**Rezoning Transportation Analysis**  
**Petition Number: Insert Zoning Petition #2021-046**  
*General Location Identifier: 08705203*

Date	Description
04-29-2021	First Review (EL&KP)
05-27-2021	Second Review (EL)

RZ1.0

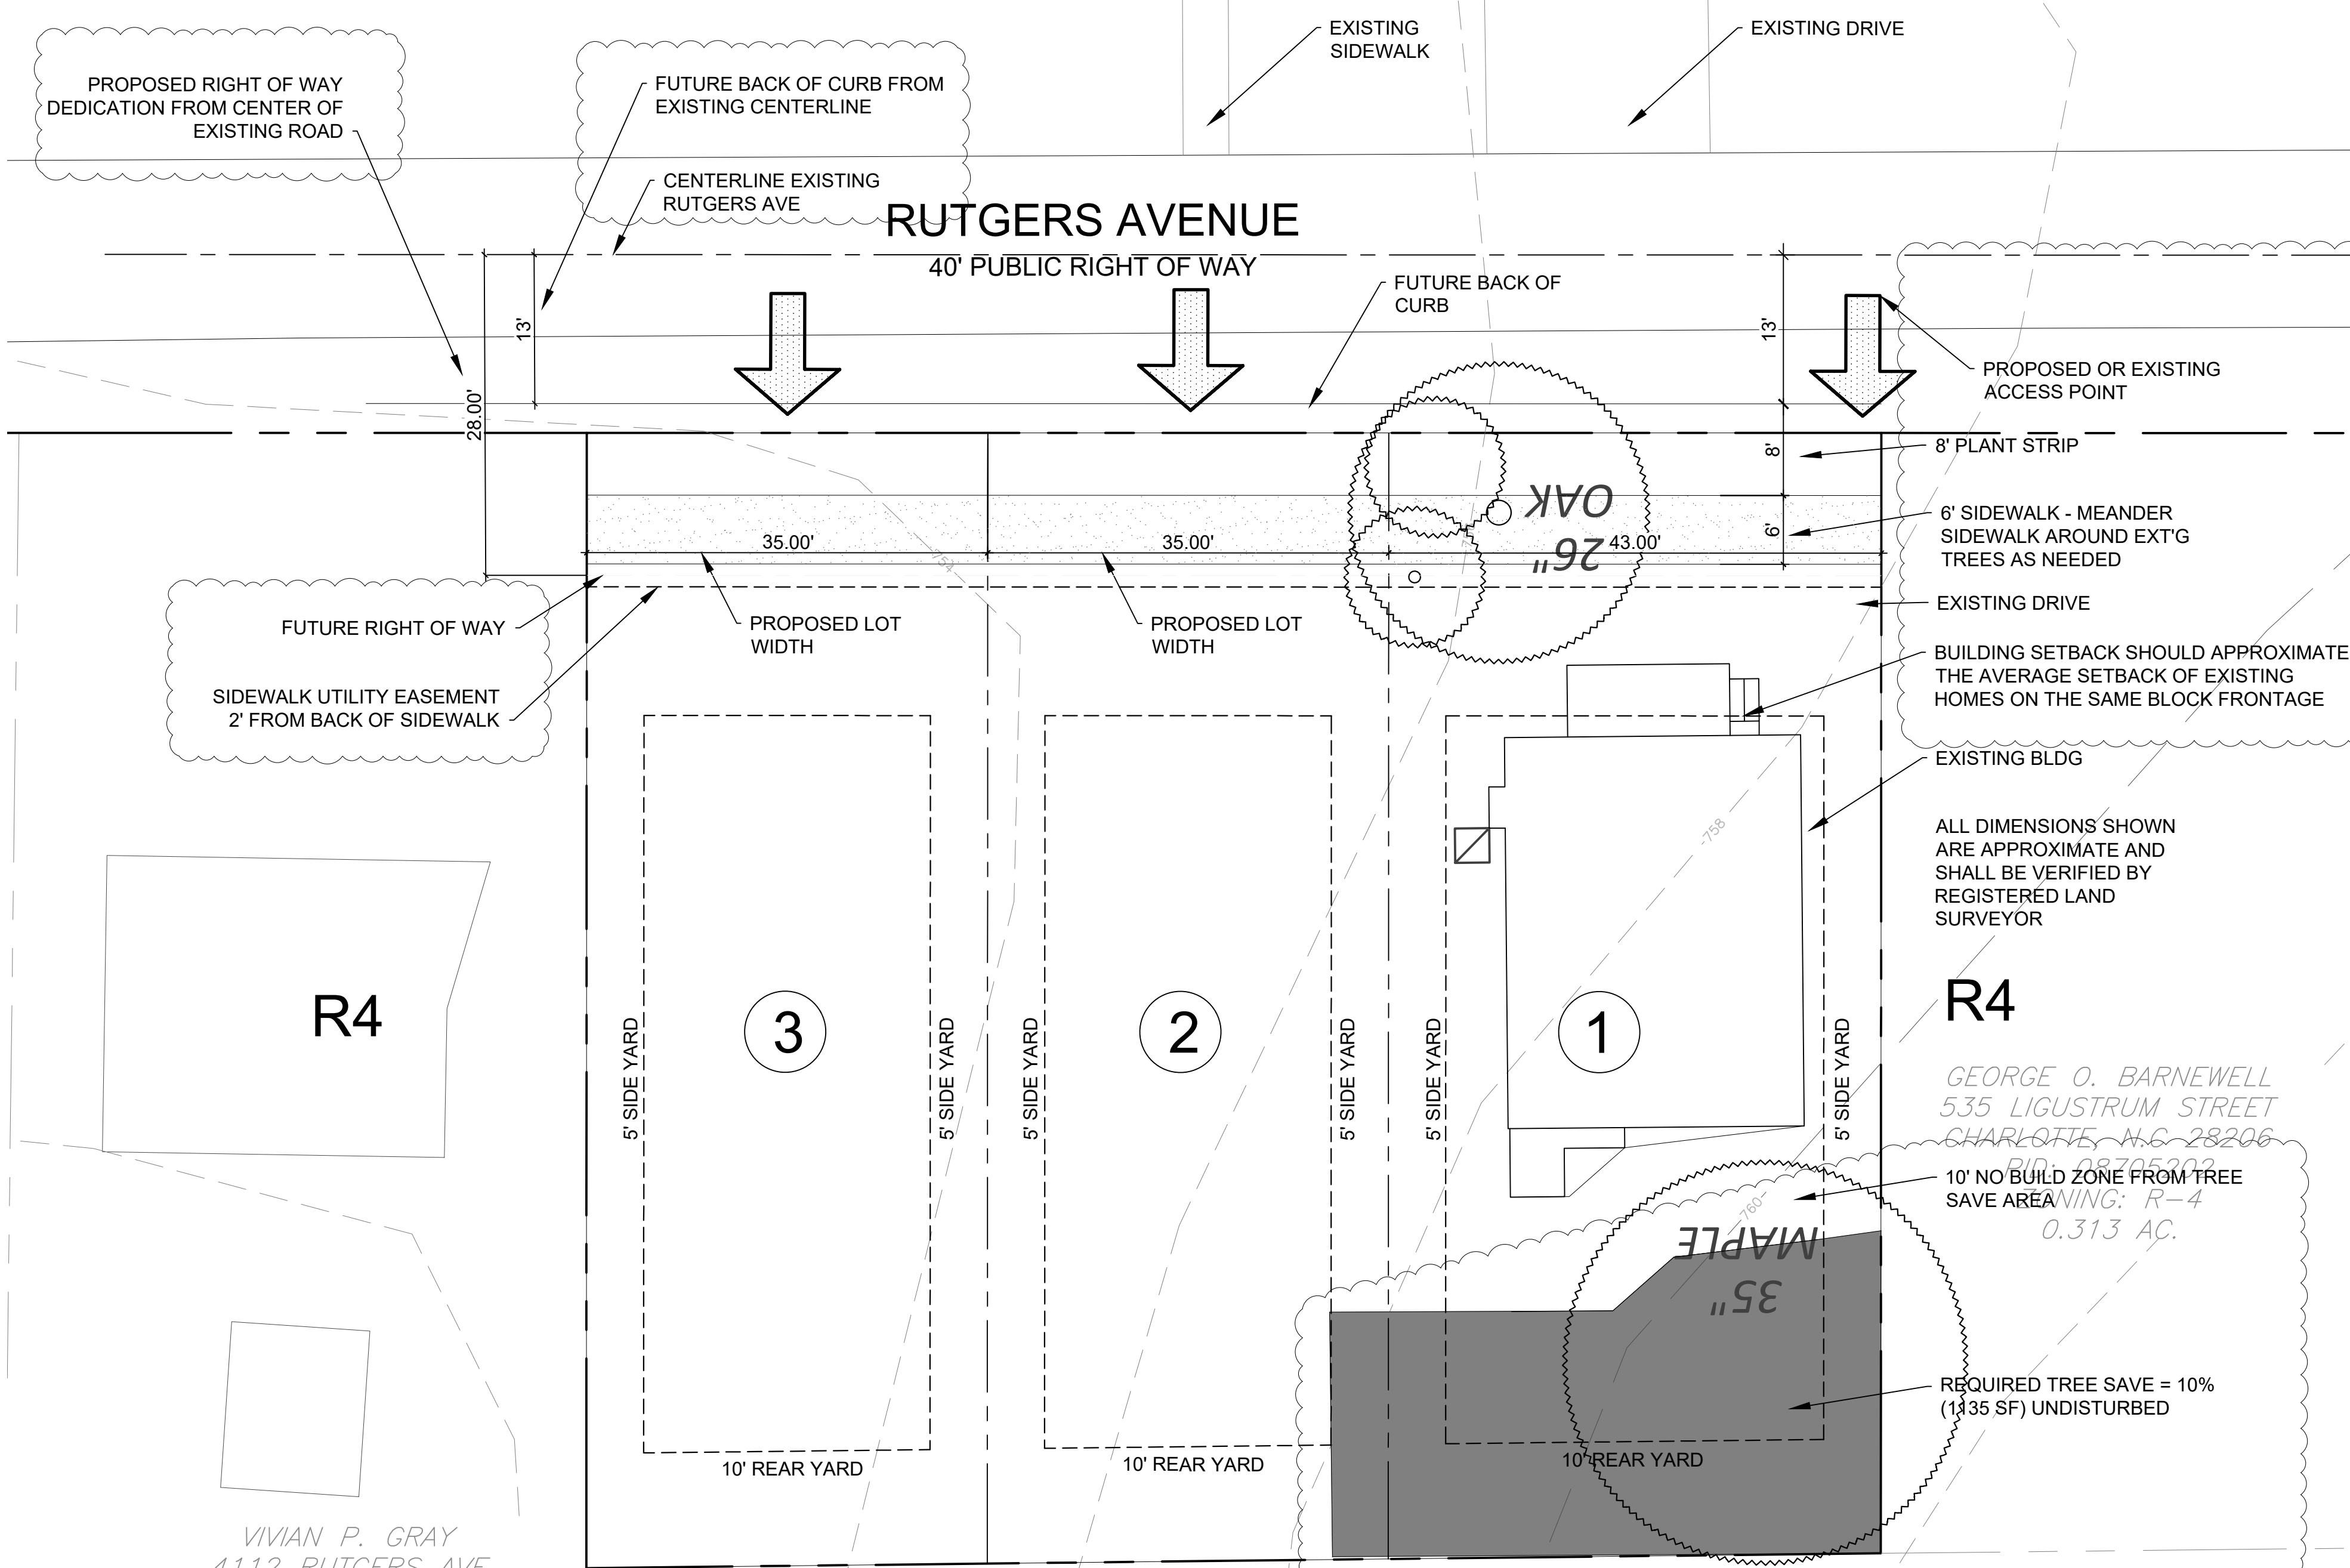
1. ~~**Curb line:** The proposed zoning district has a setback measured from back of the existing or proposed future curb line.~~
  - a. ~~**Rutgers Avenue:** The future location of curb and gutter will be located 13 feet from the existing centerline to back of curb.~~

~~Label and dimension the curb and gutter from the centerline.~~

3. ~~Revise site plan and conditional notes to commit to dedicate 28 feet of right-of-way from the Rutgers Avenue centerline. The site plan shall label and dimension the right-of-way from the road centerline.~~

4. ~~Revise site plan and conditional note(s) to commit to construct an 8-foot planting strip, and 6-foot sidewalk along the site's Rutgers Avenue frontage, per Chapter 19. The site plan shall label and dimension both items from the road centerline.~~

6. ~~Revise site plan by showing the driveway and sidewalk associated with PID 08705403 on the opposing side of Rutgers Avenue.~~

The site is located on Rutgers Avenue, a City-maintained local street that stems off Sugar Creek Road. The petitioner has committed to providing an 8-foot planting strip, 6-foot sidewalk, and right-of-way dedication along the rezoning site frontage, in accordance with City Ordinances. All CDOT items are addressed.
